Jeanie Bourke - RE: Inn at diamond Cove ceiling height

From: Jeanie Bourke
To: David Lloyd
Date: 5/7/2015 11:11 AM
Subject: RE: Inn at diamond Cove ceiling height
CC: David Bateman; Douglas Morin; Kevin Gough; jcushman@portlandbuilders.com

Jeanie Bourke
CEO/LPI/Plan Reviewer

SK-38

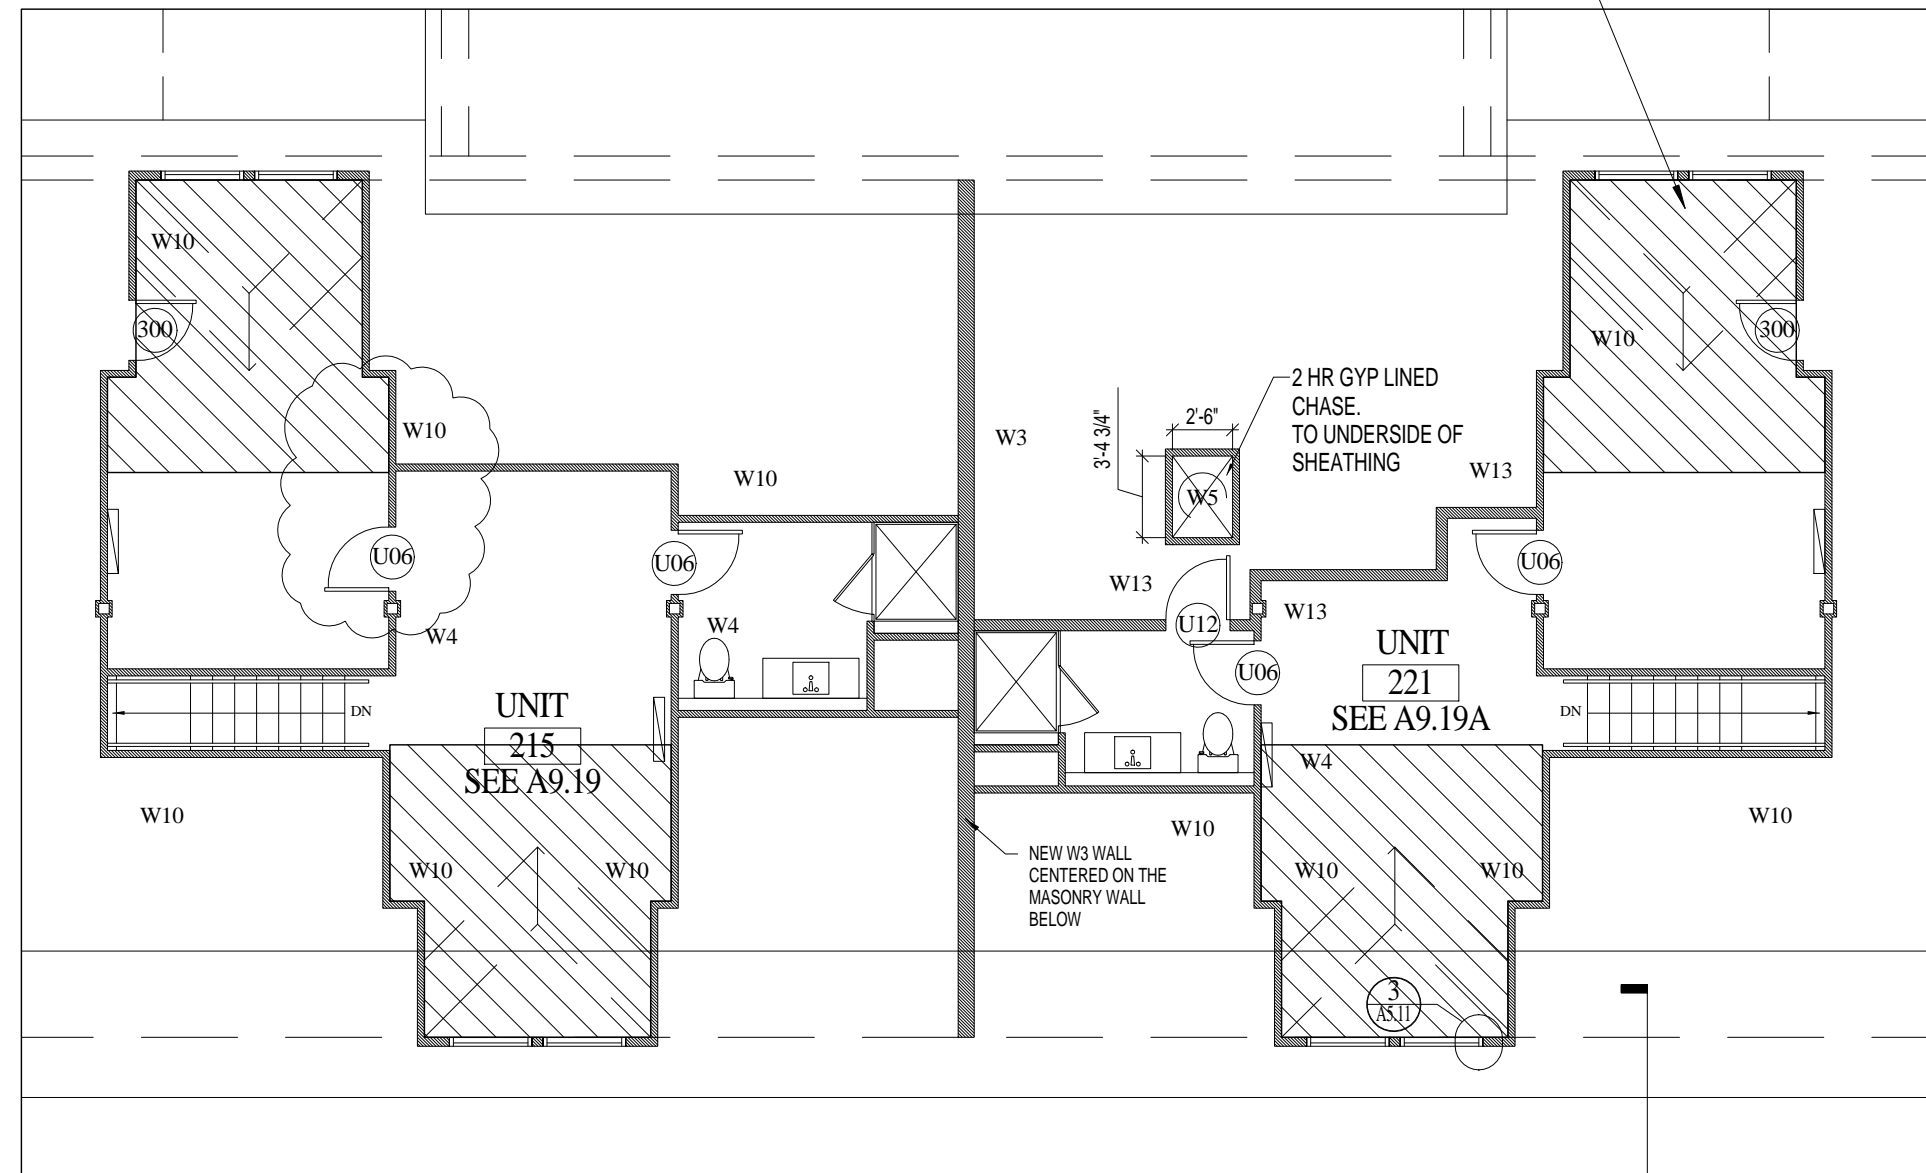
Thank you for providing more detailed information per the code requirements for minimum ceiling height. The percentage (50) of required height in each of the side bedrooms is significantly lower, at 40% of the room area. The center rooms are closer, however this 3rd floor area is recognizably confined in head room.

This all being said, in consideration of granting the historic exception, the City understands the constraints of replicating the shell of the former building in relation to the viability of this project. Additionally, these points justify approval:

1. While the ceiling height is restrictive in many ways, it is not deemed a life safety hazard.
2. While the building design utilized the IBC for new construction, in referencing the IEBC, Sec. 701.3 expc. 4, the prescribed ceiling height in newly created spaces in existing buildings can be 7'. With this, the percentage will increase and be more in line with code requirements in sloped rooms.

I will add this email and SK-38 to the approved plans folder for archiving as record of granting this exception.

We recalculated the area based upon your comments of measuring the area on a room by room basis , see attached . We are now under the 50% by a few percentages. I would therefore request that we be granted this condition under 3409.1. As the architect I would like to mention that this is an historic building , we were
